From: Planning
Sent: 23 May 2022 10:56
To: DC Support
Subject: FW: Comments acknowledgement for 22/00959/REM
Importance: High

From: Jason Trinder [REDACTED]
Sent: 23 May 2022 10:50
To: Planning <Planning@Cherwell-DC.gov.uk>
Subject: RE: Comments acknowledgement for 22/00959/REM
Importance: High

Please find amended version of text below. This is the version I would like posted on to the planning portal for 22/00959/REM.

BERRY HILL ROAD, ADDERBURY - DRAFT SITE LAYOUT

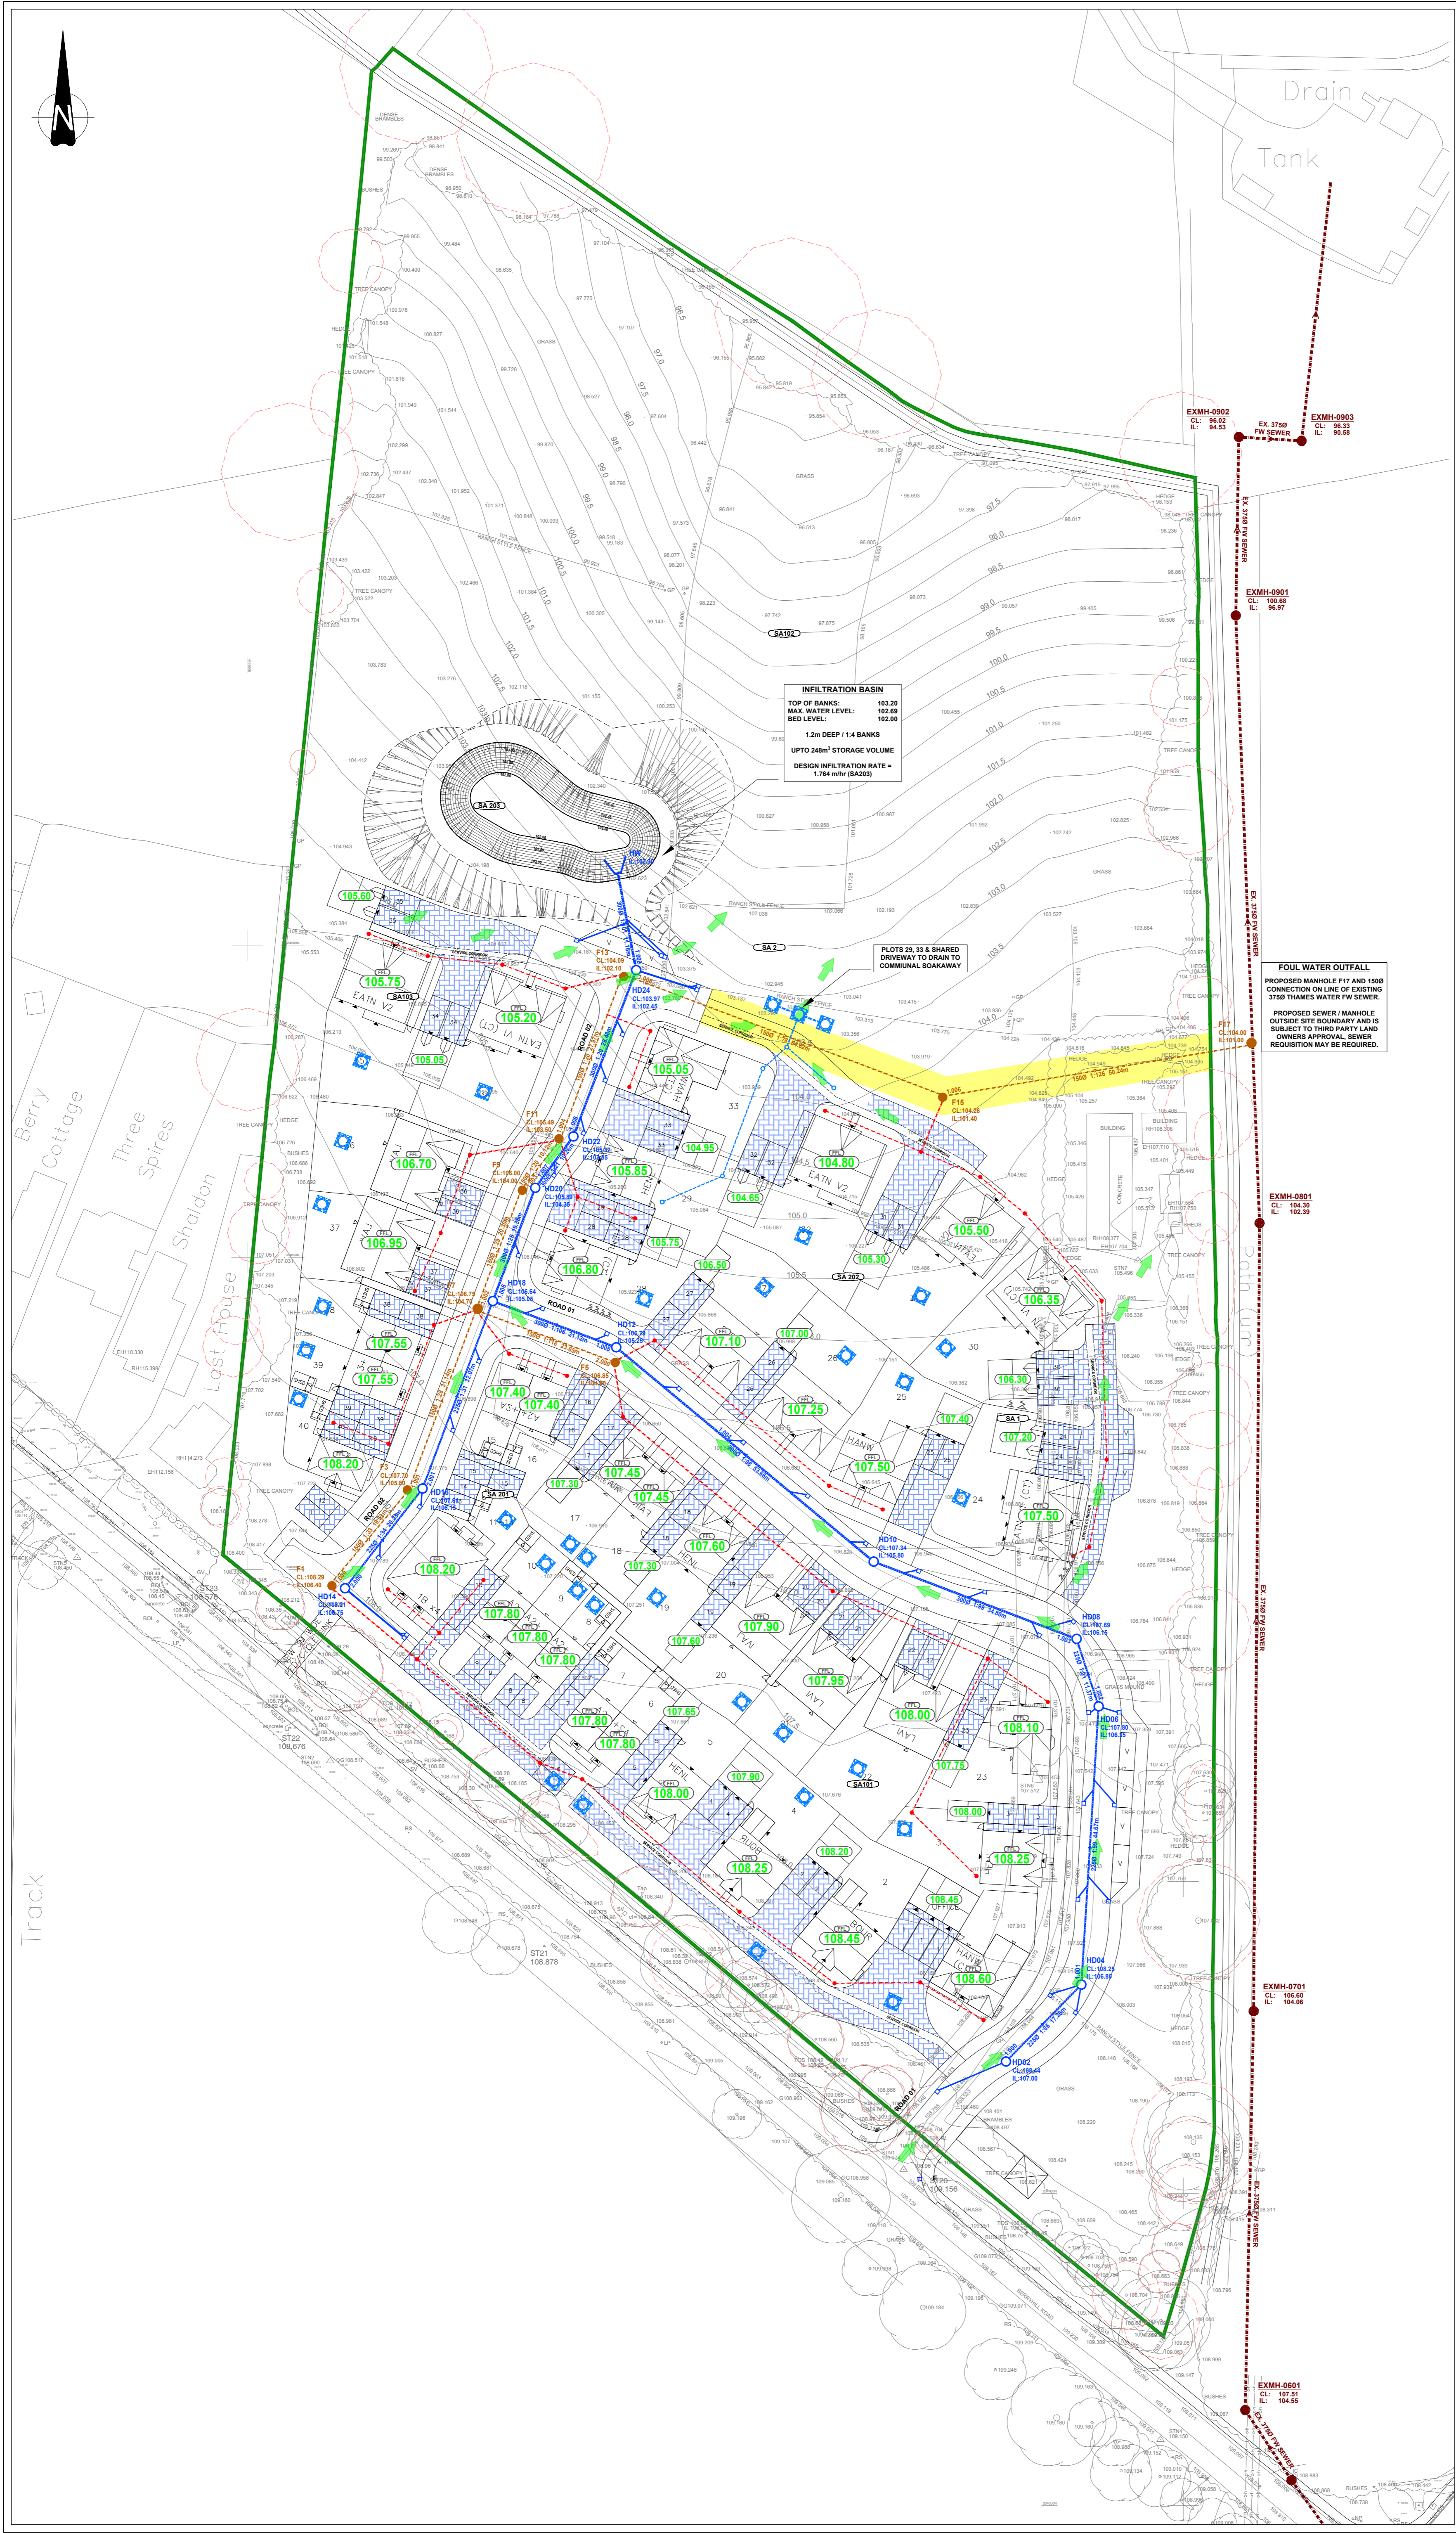
I also feel the proposed layout of the new estate has totally disregarded the impact on the neighbouring properties, especially Last House.

I am at a total loss as to why, with such a large open area, the position of the new houses are shown to be plotted right next to the existing boundary of Last House with a vast amount of open space remaining on the eastern side of the proposed development. Surely, with these proposed new houses being totally out of character with the existing properties on Berry Hill Road, it would be a far better option to move the development further to the east and have an ecological corridor located between Last House and the western boundary of the proposed new development.
